# CITY OF ALBUQUERQUE

PLANNING DEPARTMENT – Development Review Services

**RE: Partial Pond Recovery and Relocation, 6500 Alameda Blvd. NE  
Grading Plan For Grading Permit  
Engineer's Stamp Date 4-23-2014 (File: C18D079)**

COVER PAGE

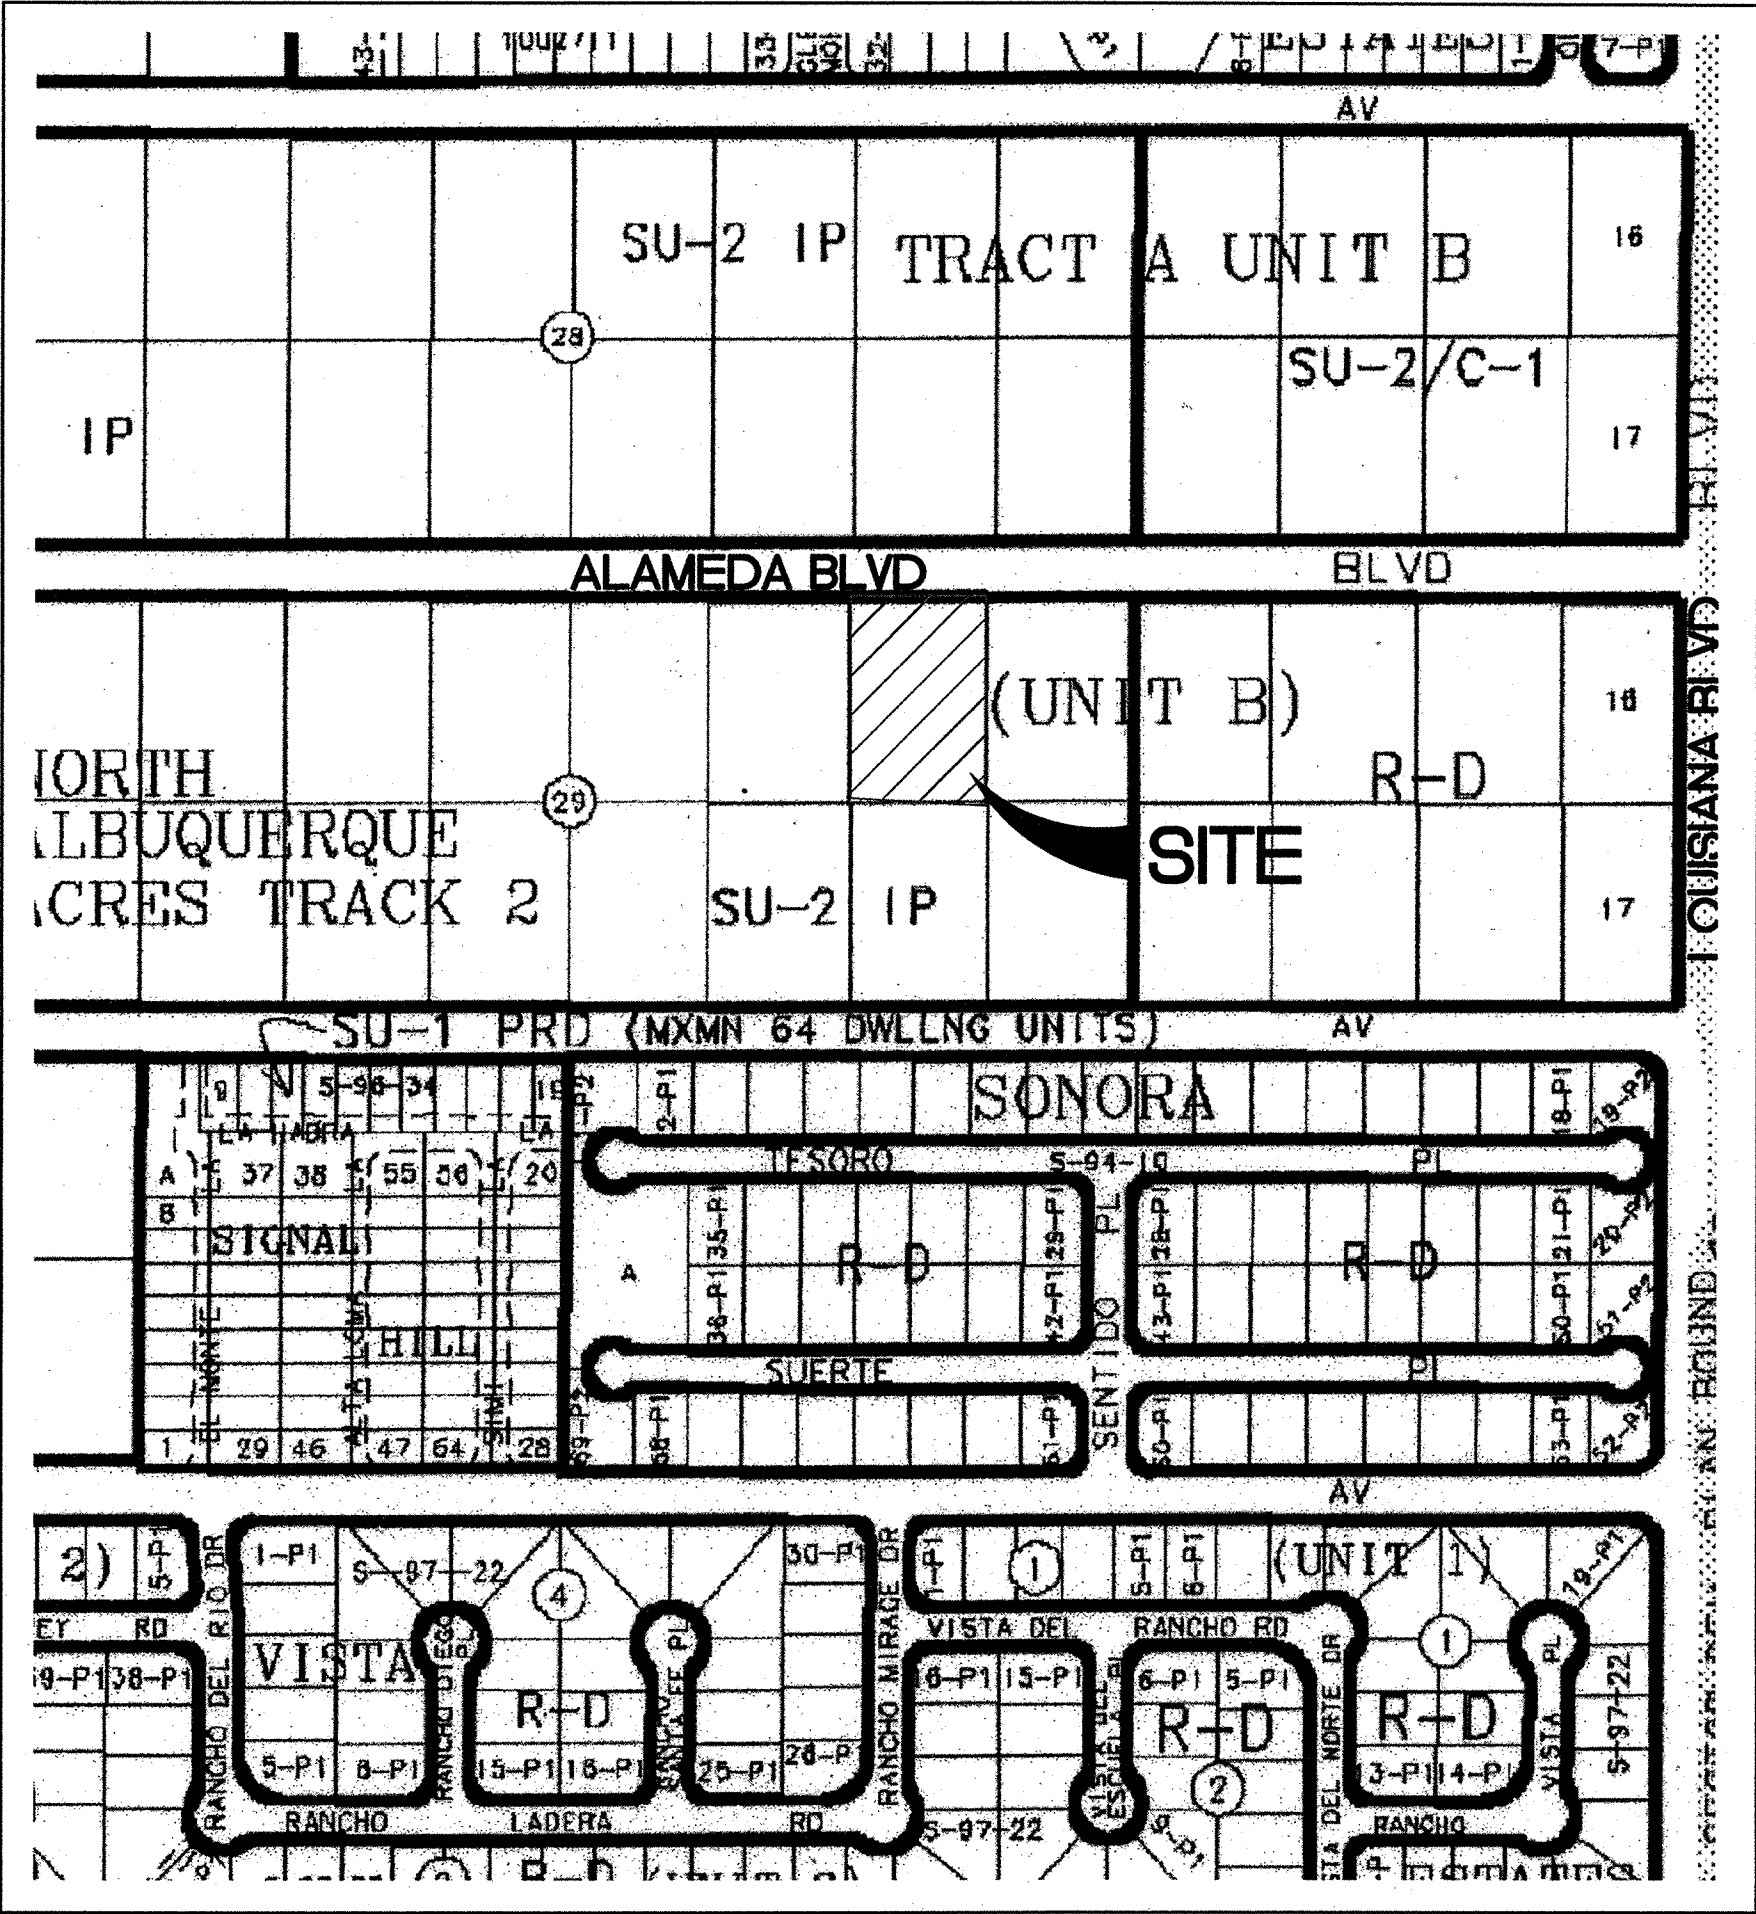
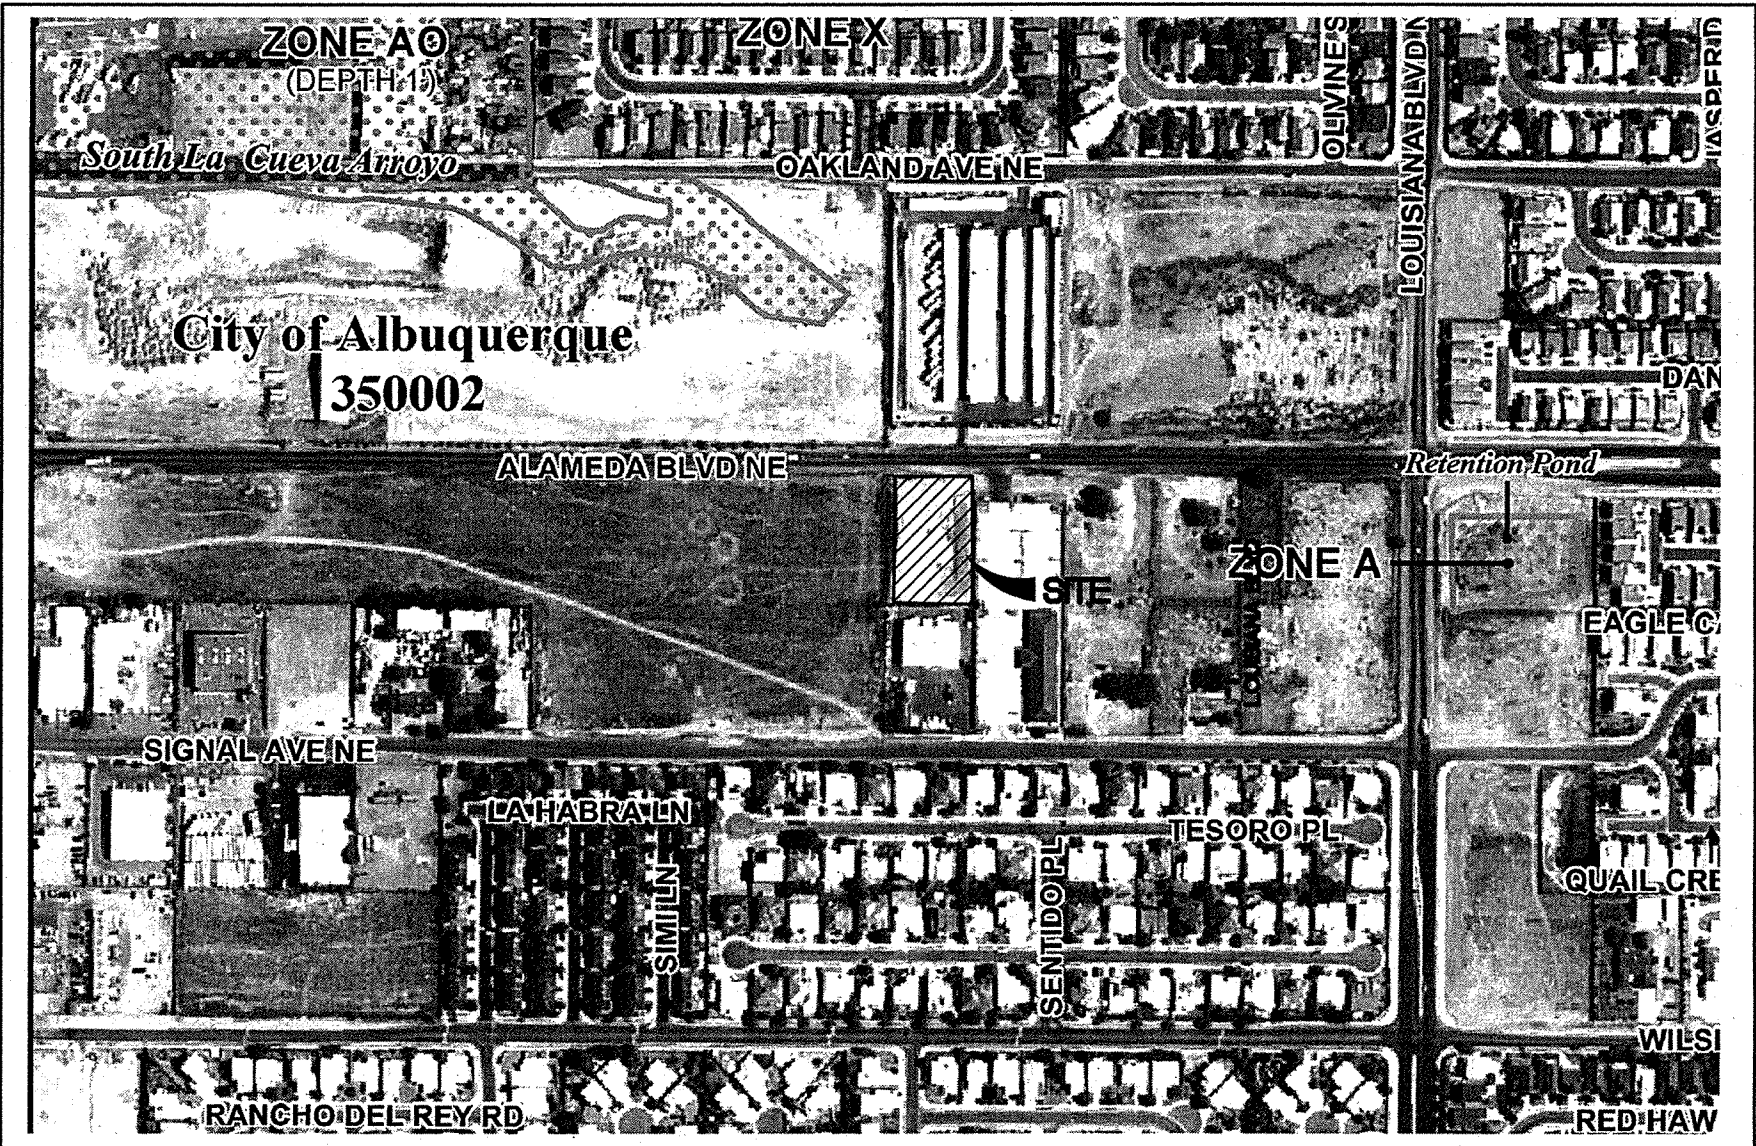
- On the title sheet, correct the Existing Conditions narrative as it is partially unreadable.
- On the title sheet, correct the Developed Condition narrative to state that pond is to contain flows from Lot 11 only.
- Also, it would be helpful to include the Lot No.'s in the Vicinity Map referenced in the narratives.
